From: Tim Townsend [REDACTED]
Sent: 03 August 2016 15:27
To: Planning.Responses
Cc: Richard Temple; Tony Sutcliffe
Subject: P/76/16/PL - Proposed packing and preparaiton building - Sefter Farm (Barfoots), Pagham Road, Pagham.
Follow-up Public Rights of Way (PRoW) and Fire and Rescue Service (F&RS) comments

**WEST SUSSEX COUNTY COUNCIL
STRATEGIC PLANNING CONSULTATION**

SUBJECT: P/76/16/PL - Construction of a building for the packaging, preparation & distribution of fresh foods with ancillary accommodation associated with the existing horticultural business, revisions to internal access road, car parking & hardstanding areas & landscaping & provision of a wetland. This application affects the setting of Listed Buildings.

LOCATION: Sefter Farm, Pagham Road, Bognor Regis, West Sussex, PO21 3PX.

Drawing: Reedbed layout & mitigation

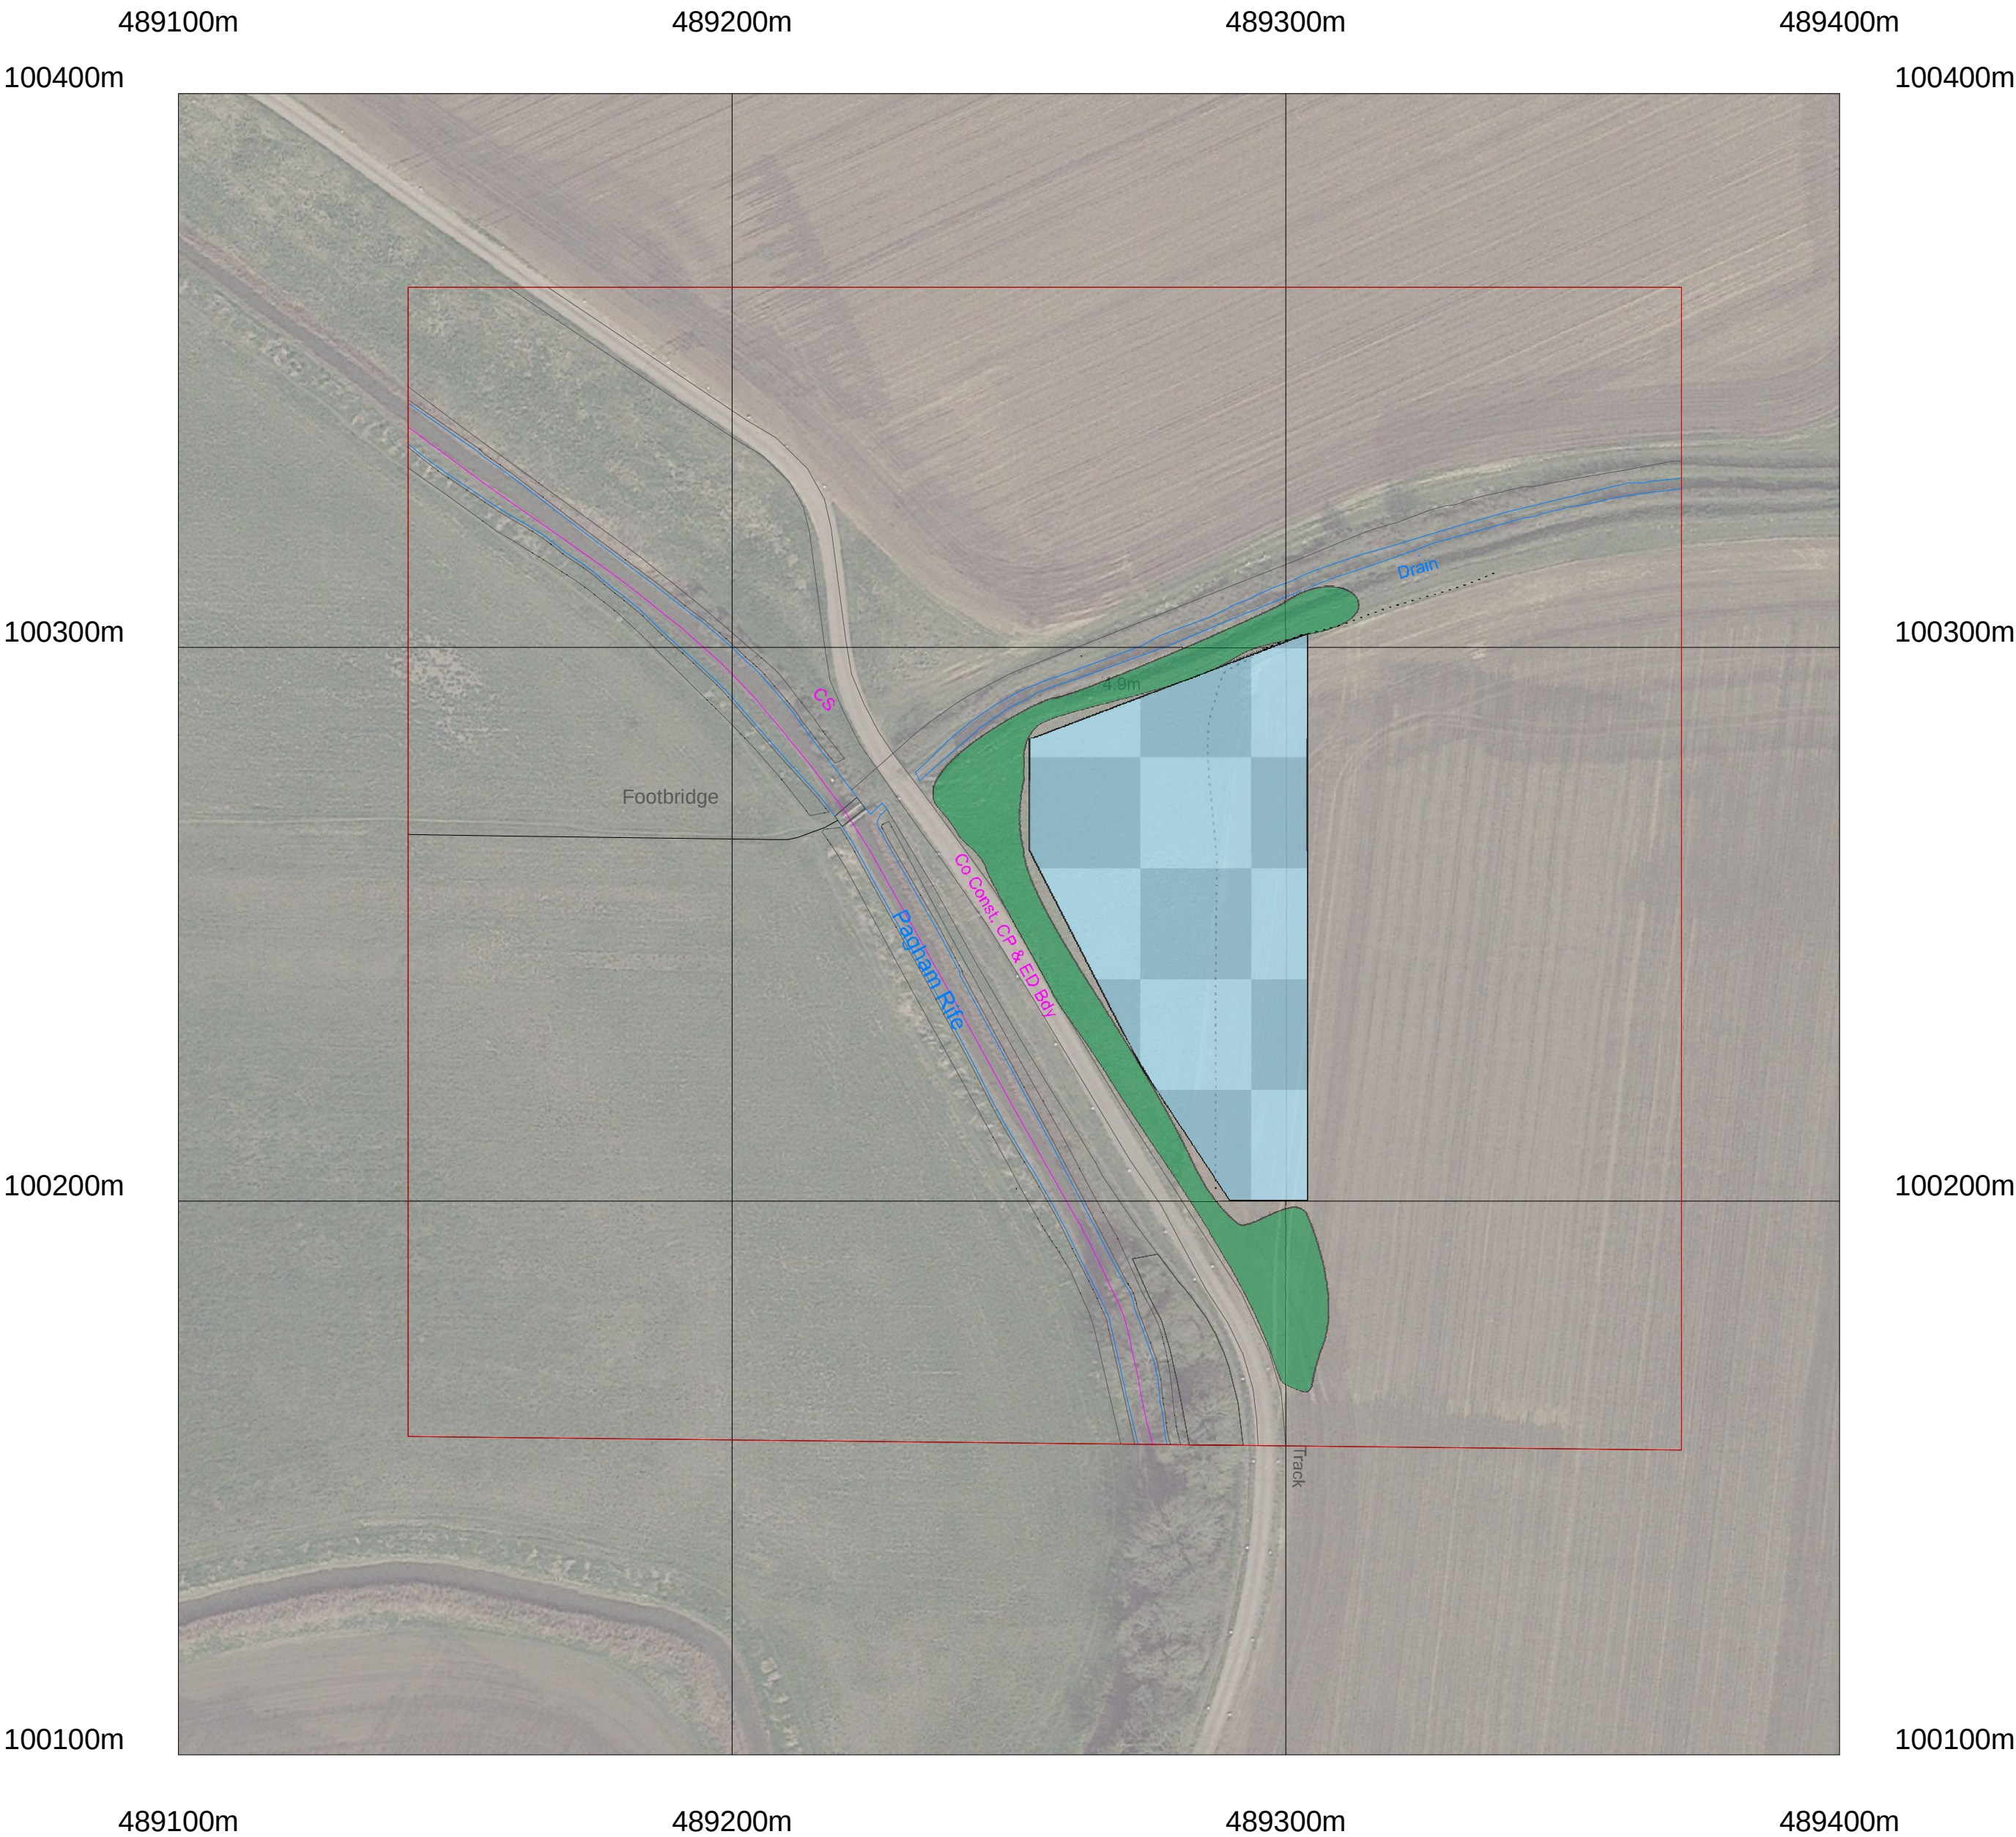
Whilst the main part of the application does not directly impact on the bridleway known as BW129, there is the reed bed and wetland mitigation which is very close to the southern boundary to the bridleway.

This particular area does get very wet especially during the winter months. The bridleway also drains downhill to this area (corner of the field to the Pagham Rife). The creation of the wetland area and reed bed could be of great benefit to hold water and provide good wildlife habitat, it also could improve the drainage in the area which would benefit the bridleway. However, before we can offer our support to this application we would like further clarification as to how the wetland area is to be constructed and if there is any opportunity to take some of the surface water from the bridleway into the wetland area to therefore improve the bridleway drainage at this point. We would also ask for further assurances that this will not make the bridleway any wetter. **Please consider this as a holding objection until we have the further clarification as requested.**
